In response to Applicant's Response to Relevant Representations: RR-038

RE: REQUEST FOR ADDITIONAL VISUAL RECEPTOR AT LOWWOOD

Figure 7.4 Visual Receptor Location Plan

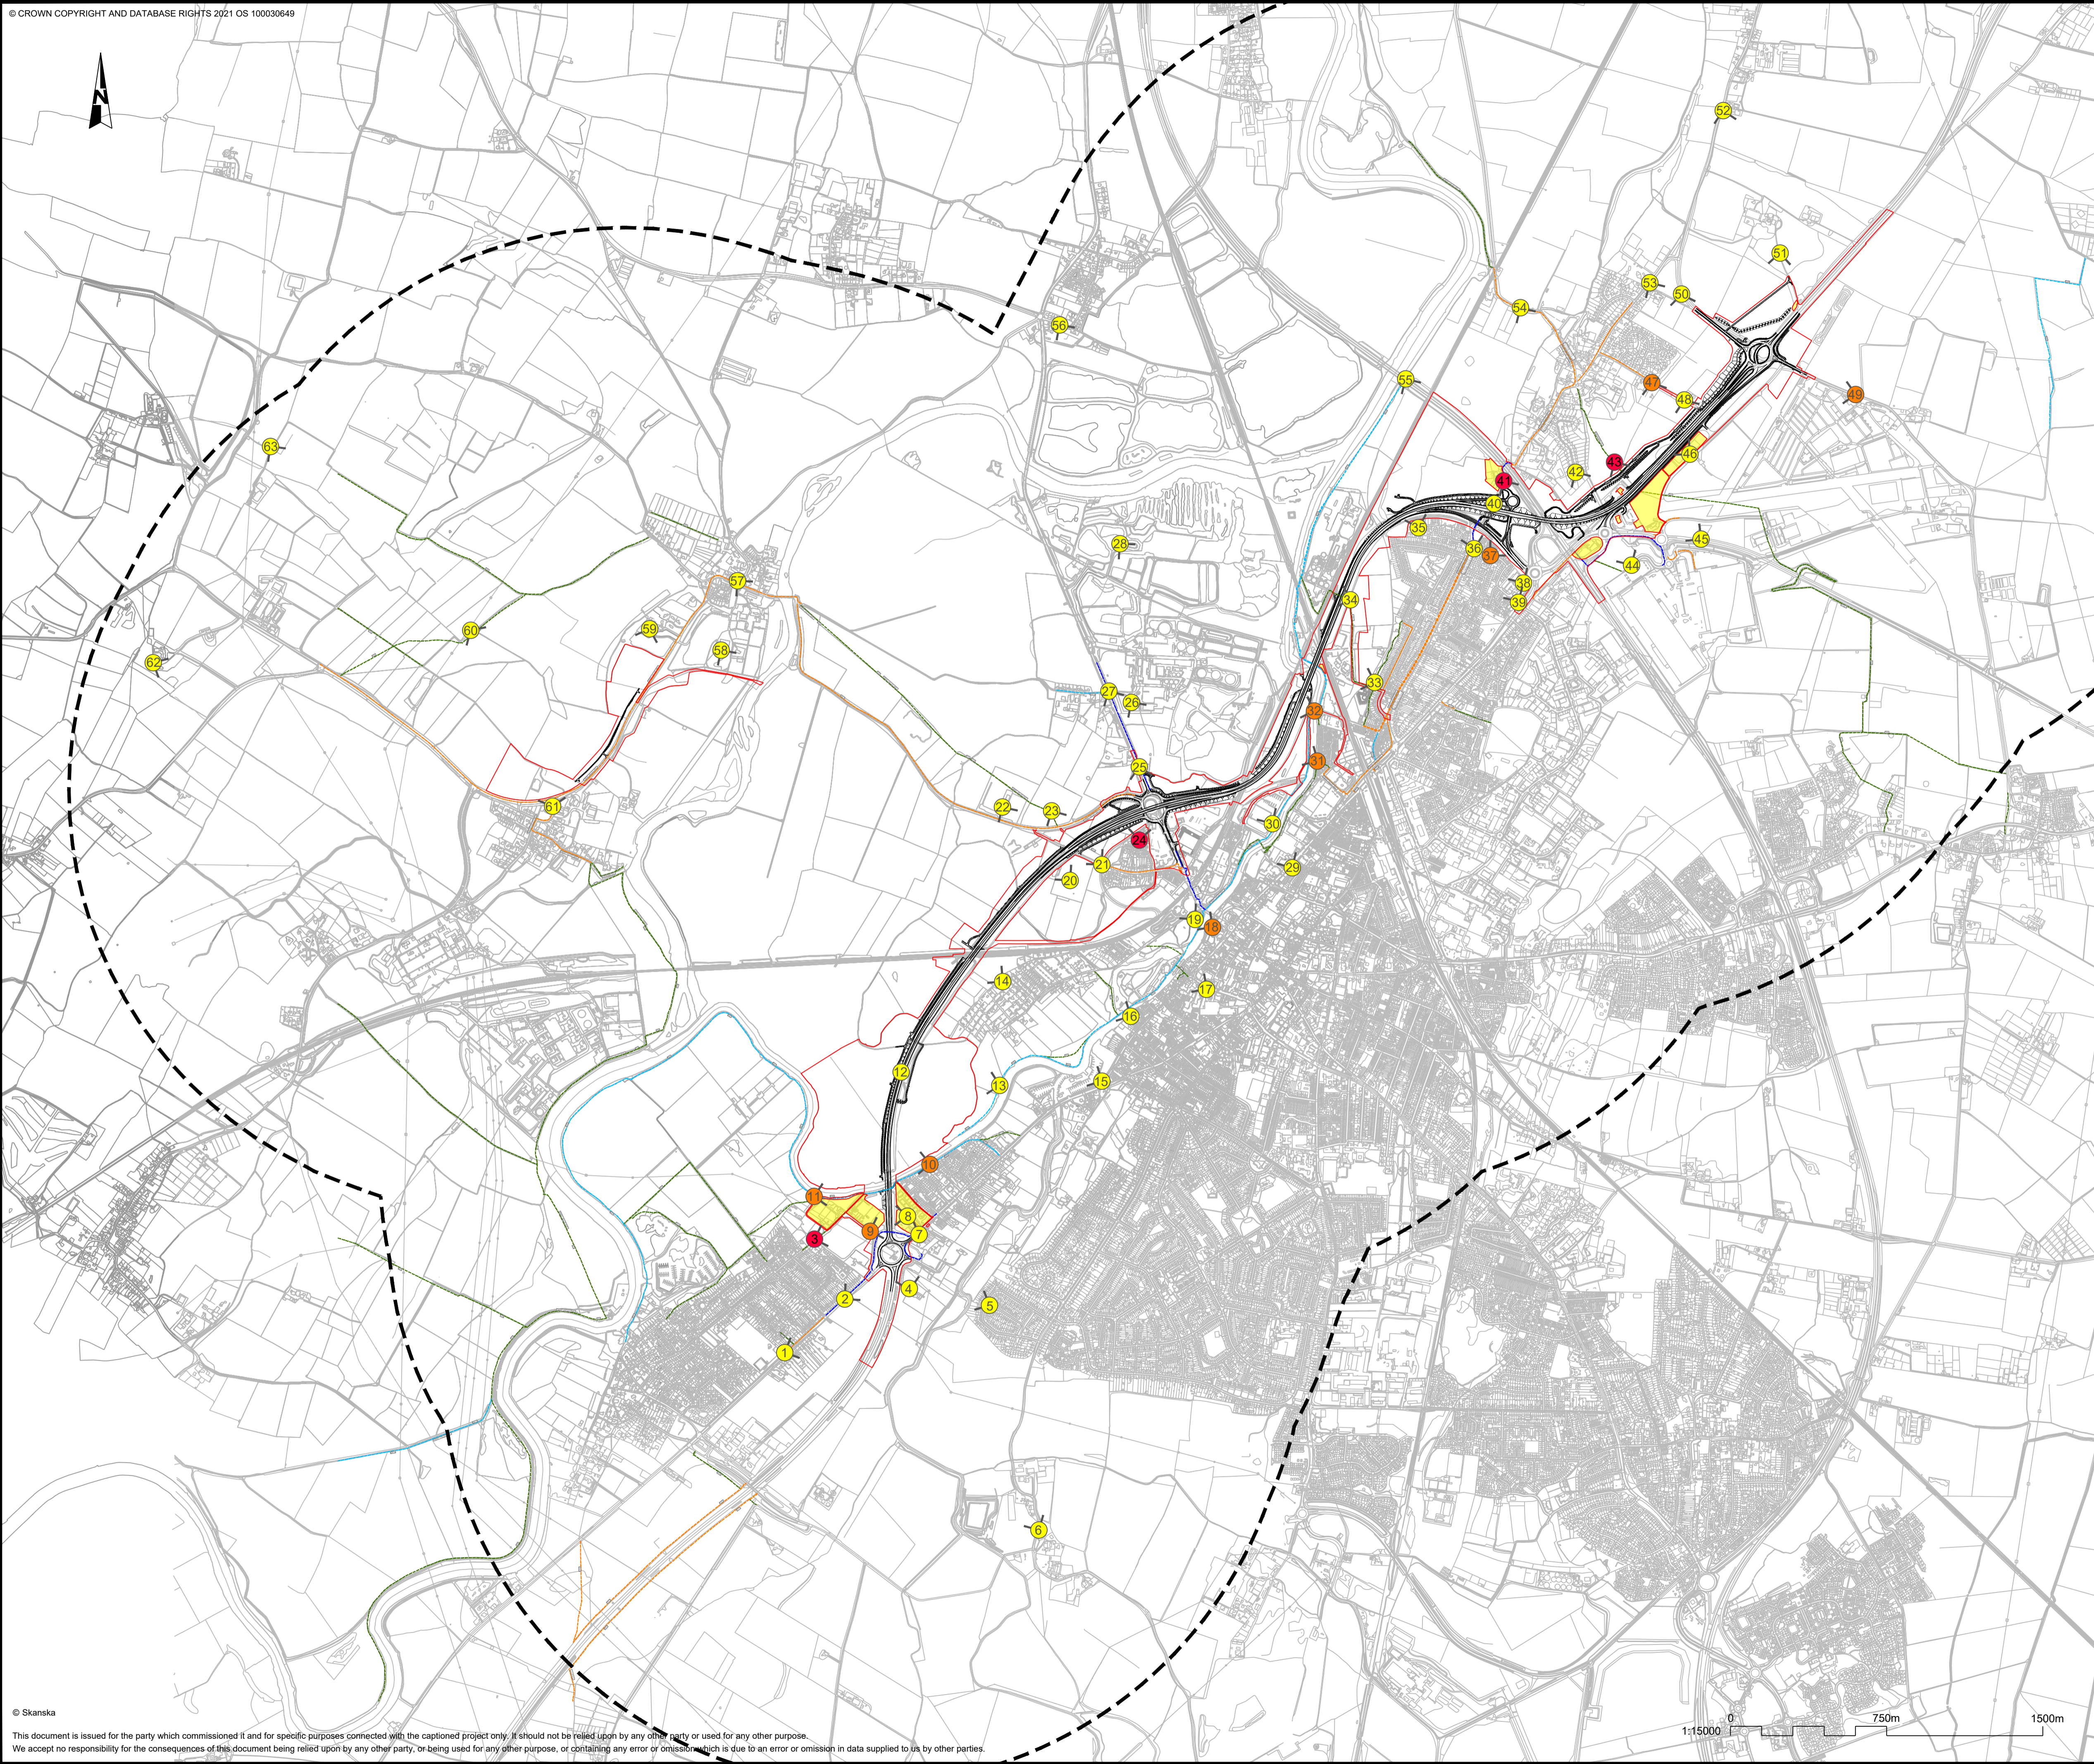
Despite the applicant's comments I still do not believe that the visual impact on Lowwood- Grade II listed building of historical interest- is covered sufficiently in the applicant's reports. Visual receptor number 42 is not suitable for assessing the impact on this property due to its location behind houses on The Spinney. An additional receptor is required further to the SouthWest in the area between Lowwood itself and the Mint Leaf site, or thereabouts. This grade II listed building is the view of the south side of the Winthorpe conservation area and this has not been properly documented. An acknowledgement of the hazard to this location is needed, together with some proposals for mitigation. I welcome the visit from the examination authority now planned on Friday December 6th 2024.
